**WEST SUSSEX COUNTY COUNCIL
PLANNING SERVICES CONSULTATION**

DATE: 31st July 2017

SUBJECT: WA/44/17/OUT - Outline application with some matters reserved for up to 175 dwellings, new vehicular access, together with associated car parking, landscaping & community facilities to include allotments, play space & community orchard. This application is a Departure from the Development Plan & may affect the character & appearance of the Walberton Village Conservation Area.

Land East of, Tye Lane, Walberton, West Sussex

RIGHT TURN LANE EXTENDED BY 80m
TO CREATE ADDITIONAL STORAGE

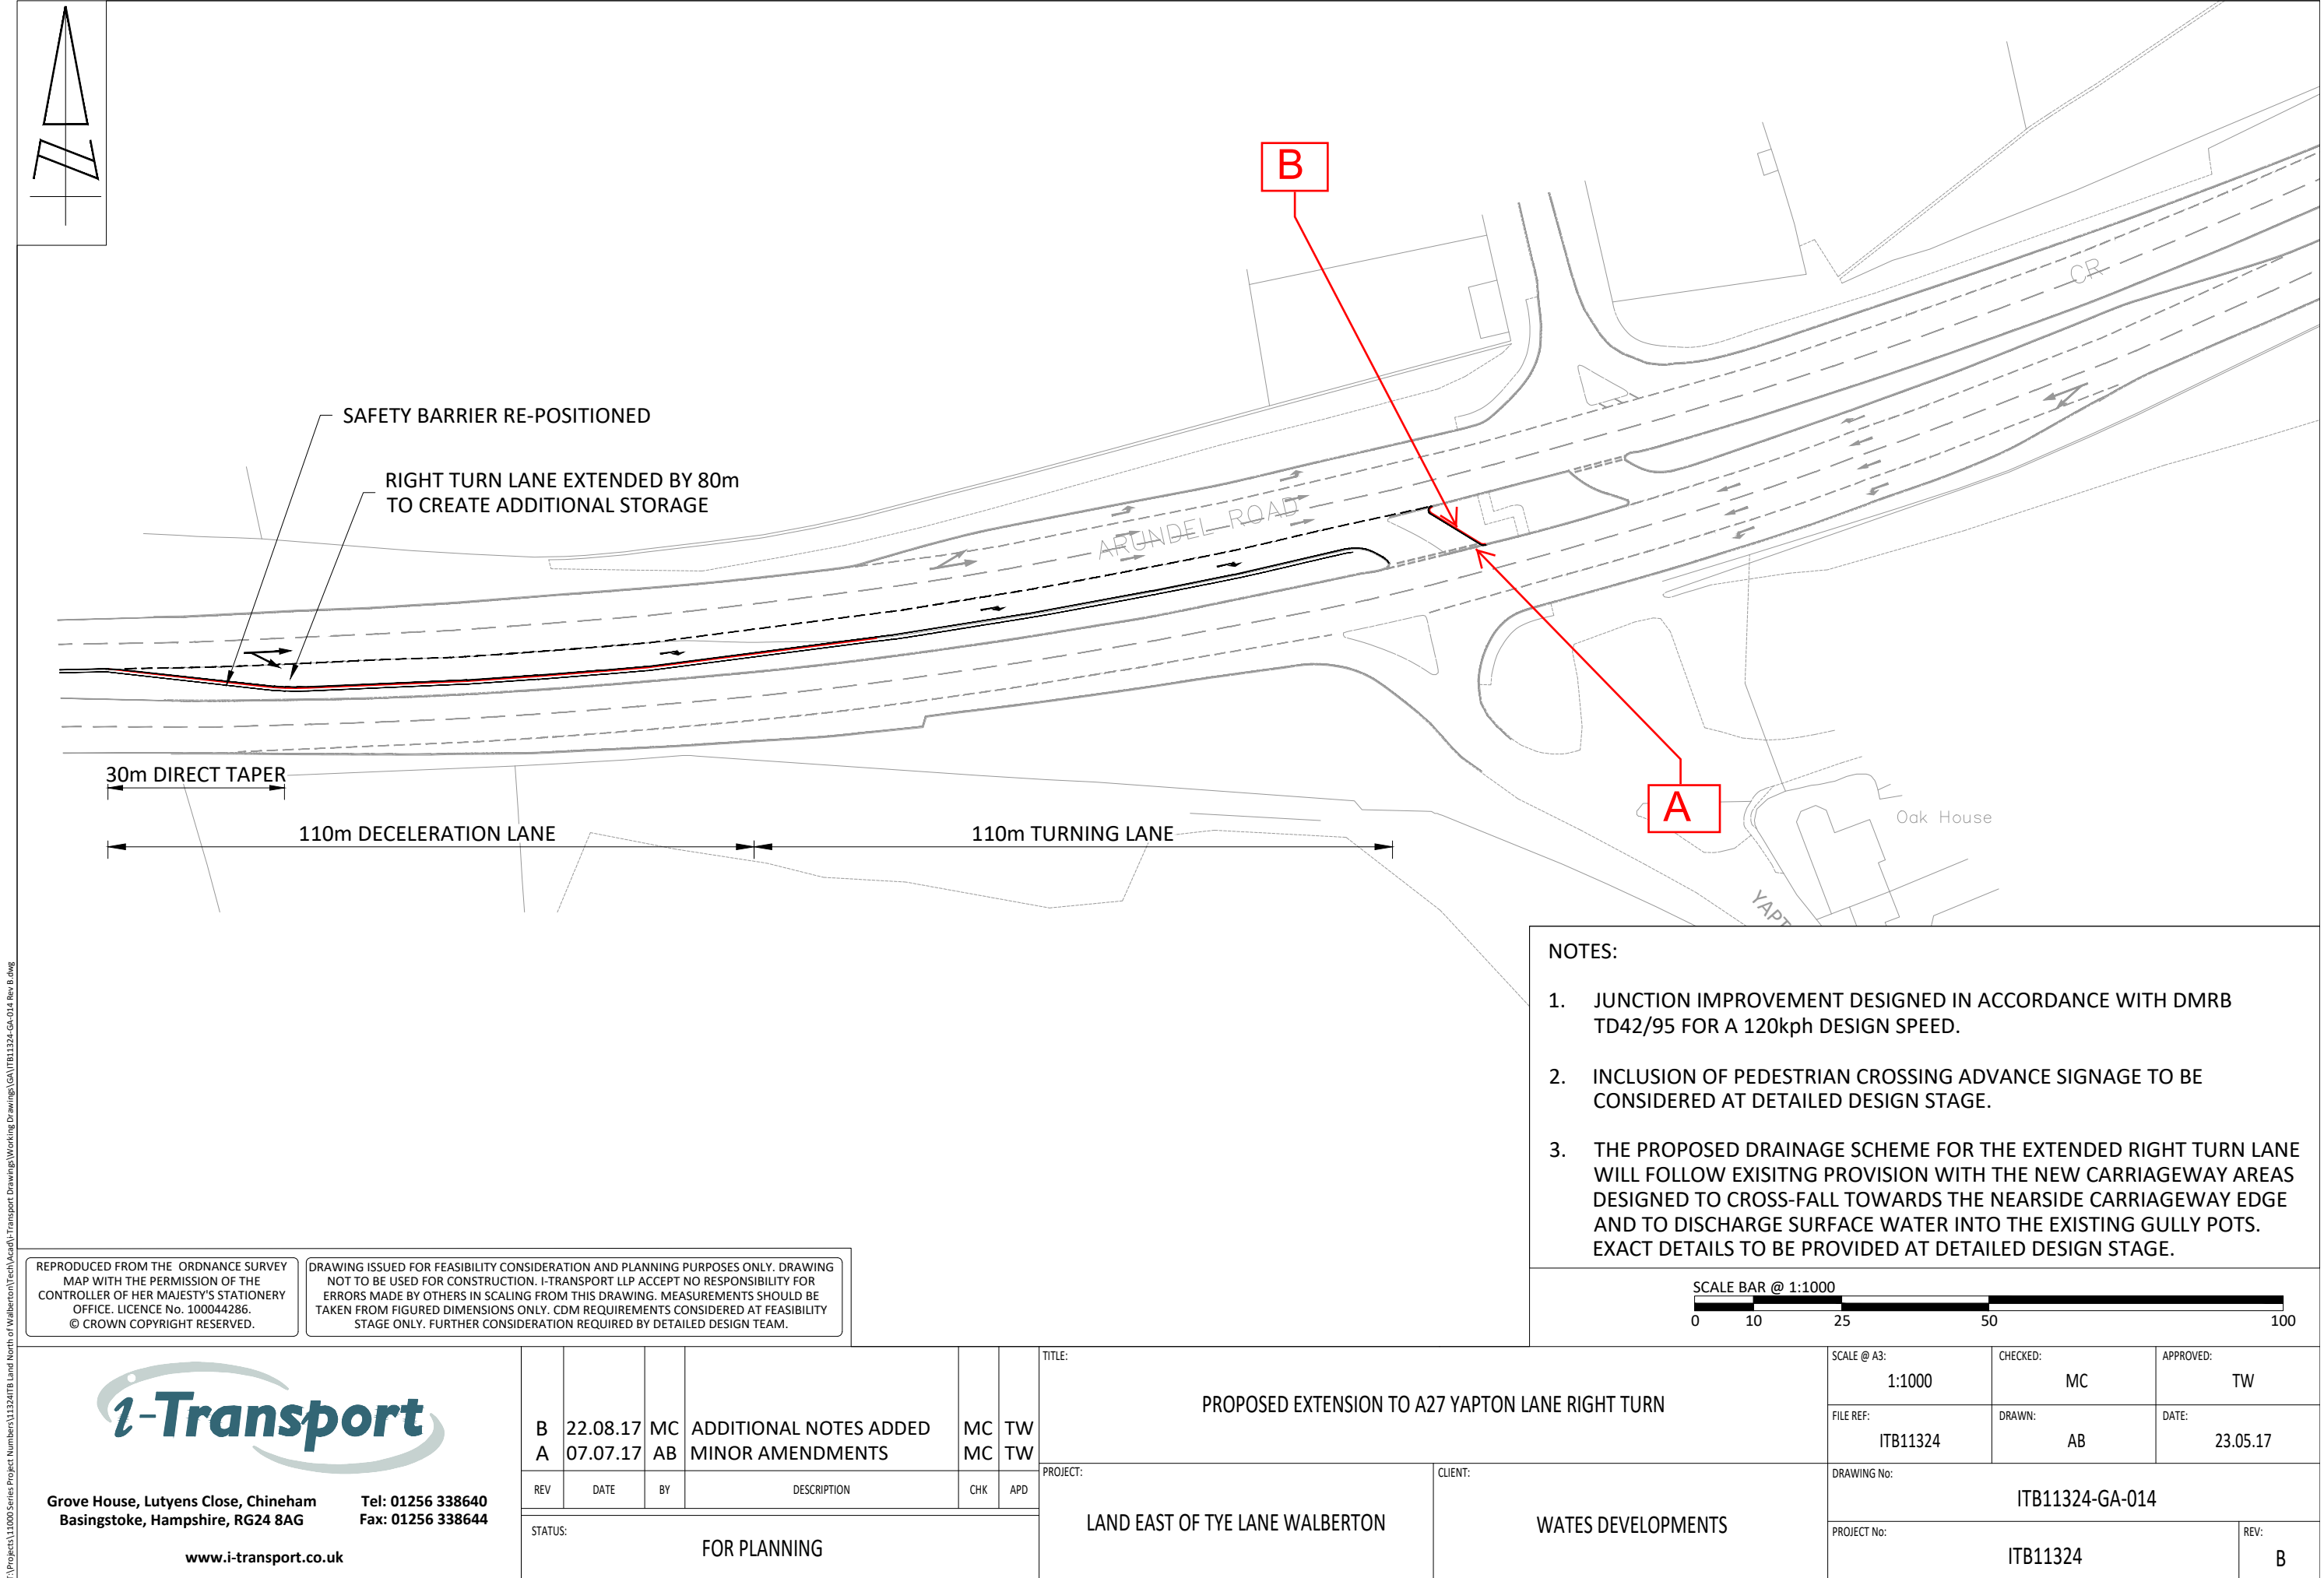
Modelling and Queue surveys have been undertaken upon the right hand turn into Yapton Lane from the A27. Following discussions with Highways England the applicant is to extend the right hand turn lane by 80m.

T:\Projects\11000 Series Project Numbers\11324\ITB Land North of Walberton\Tech\Acad\Transport Drawings\Working Drawings\GA\ITB11324-GA-015 Rev B.dwg

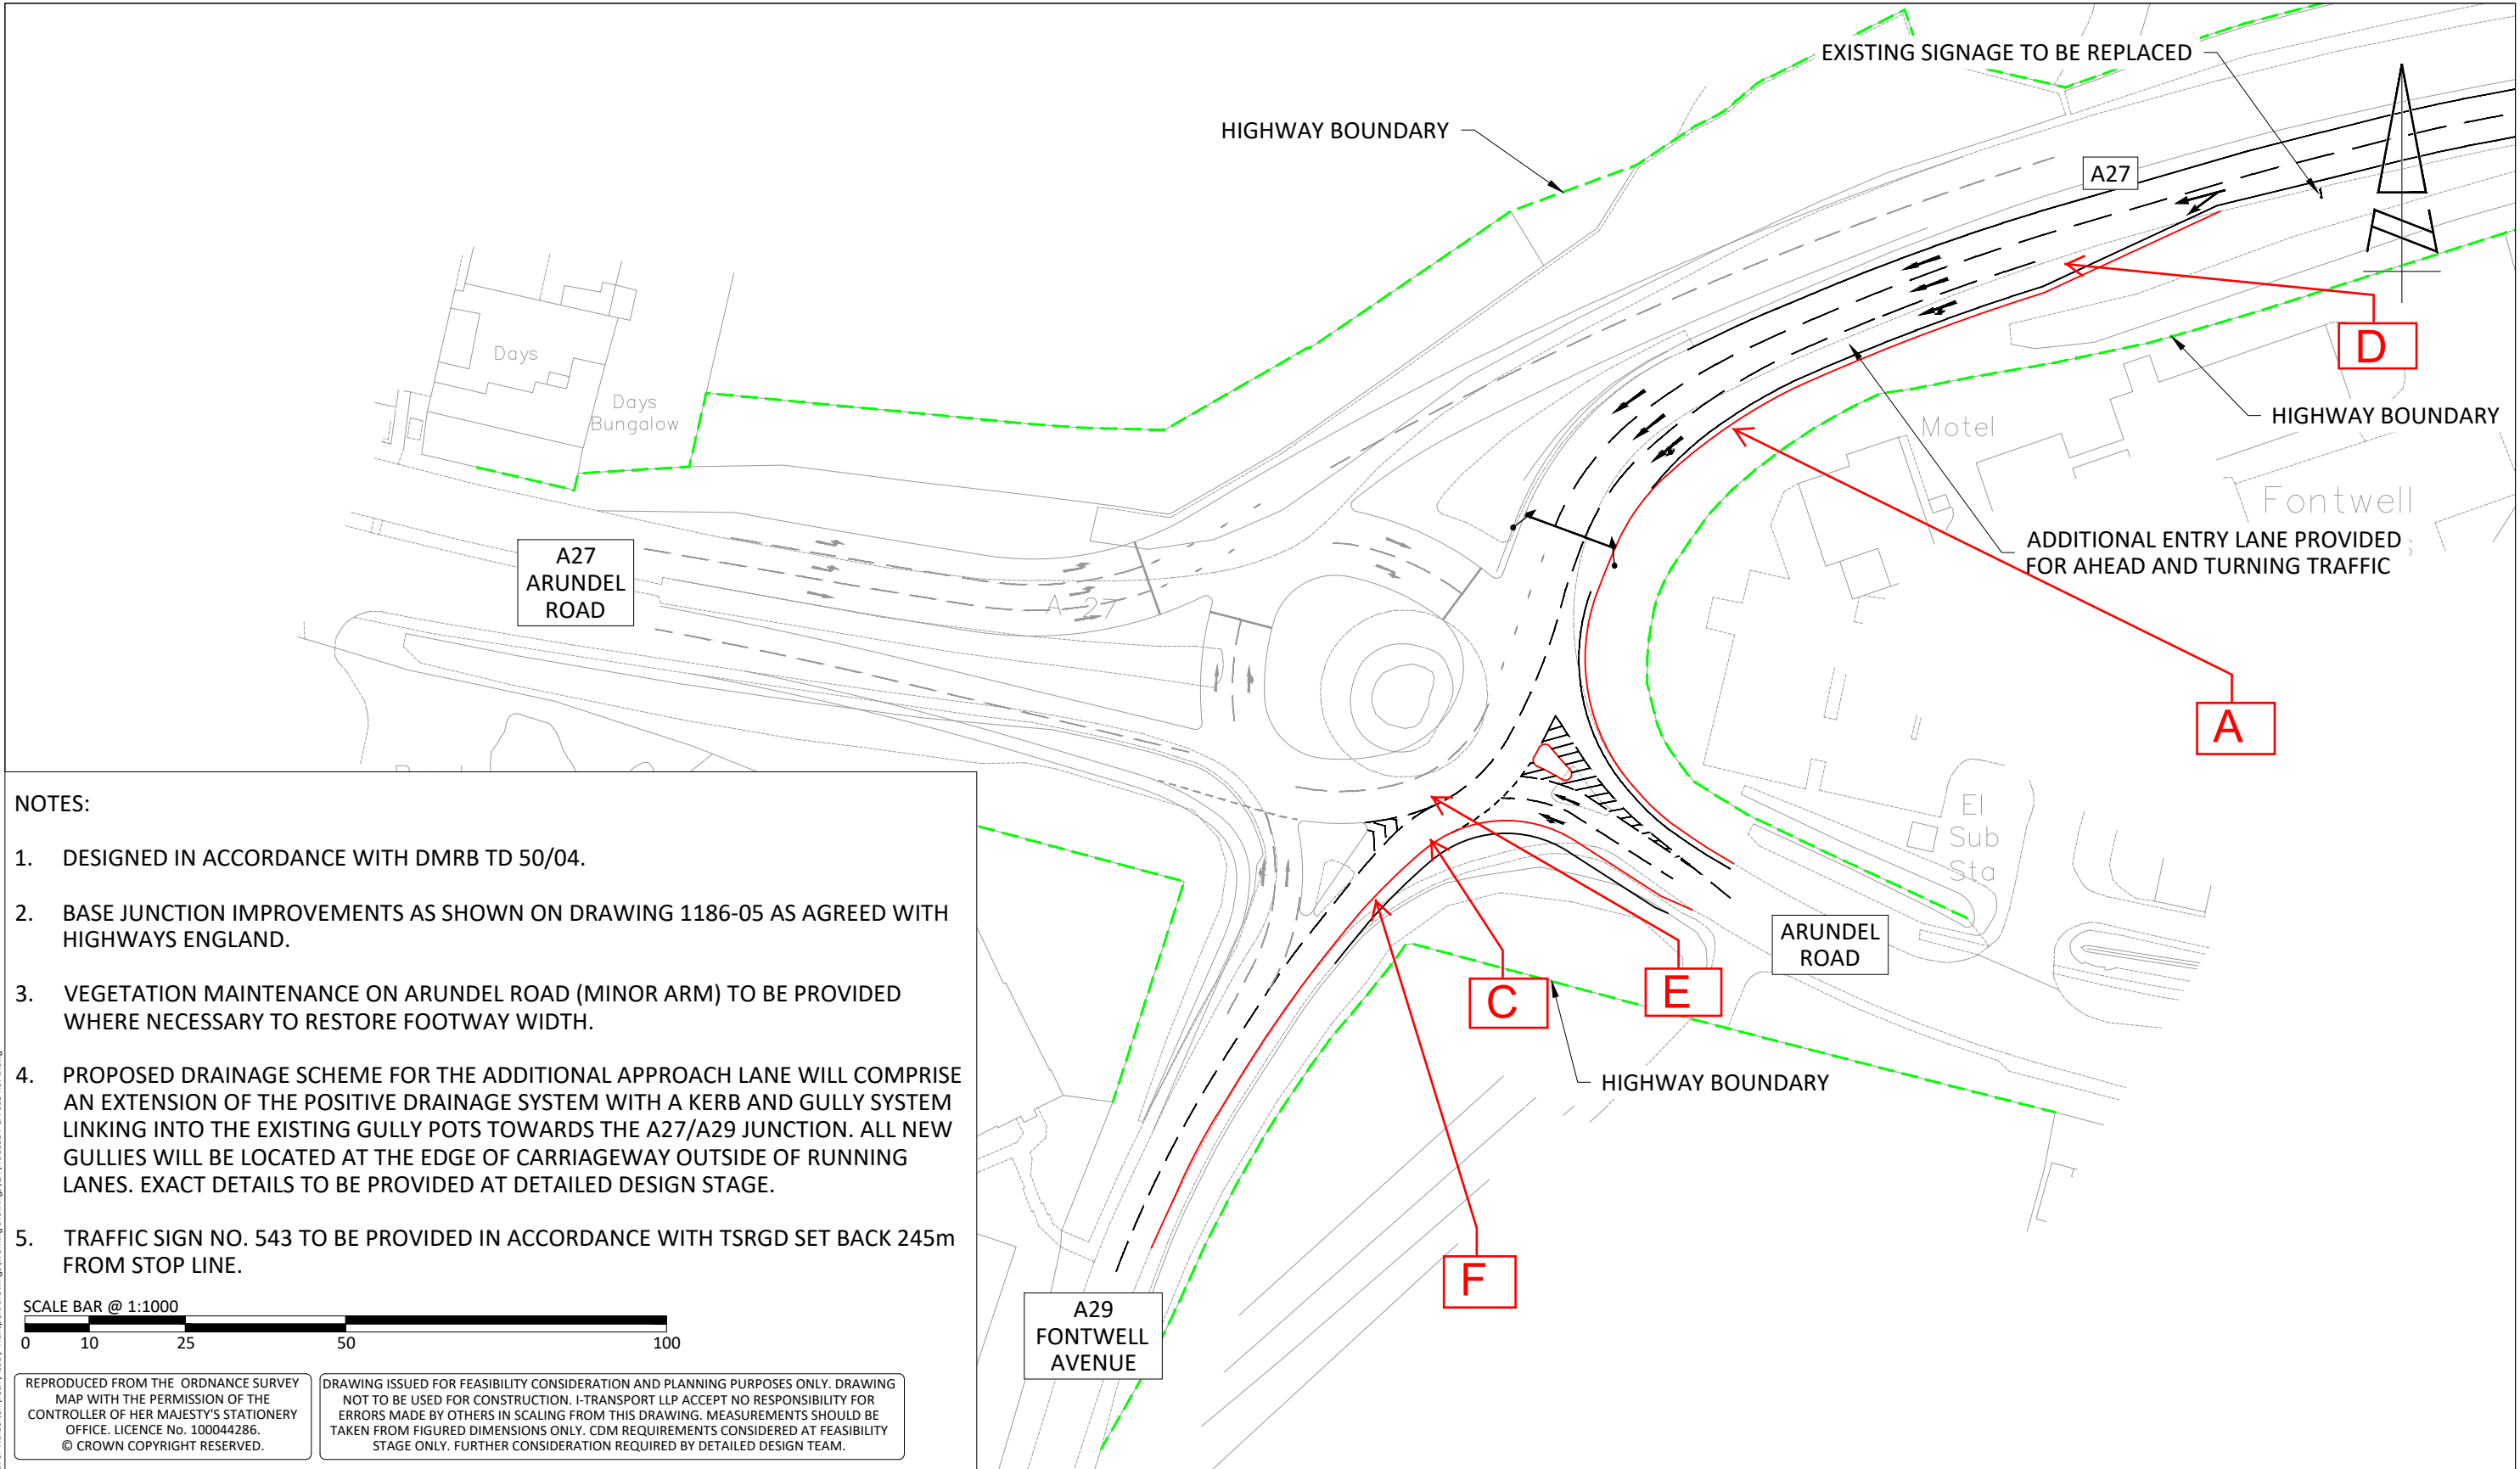
The modelling highlights that mitigation is required over and above the local plan scheme (associated with the Fontwell meadows development) and as such an additional improvement is proposed to include additional entry lane on the A27 east approach to the junction and enable left and ahead traffic to utilise the nearside lane.
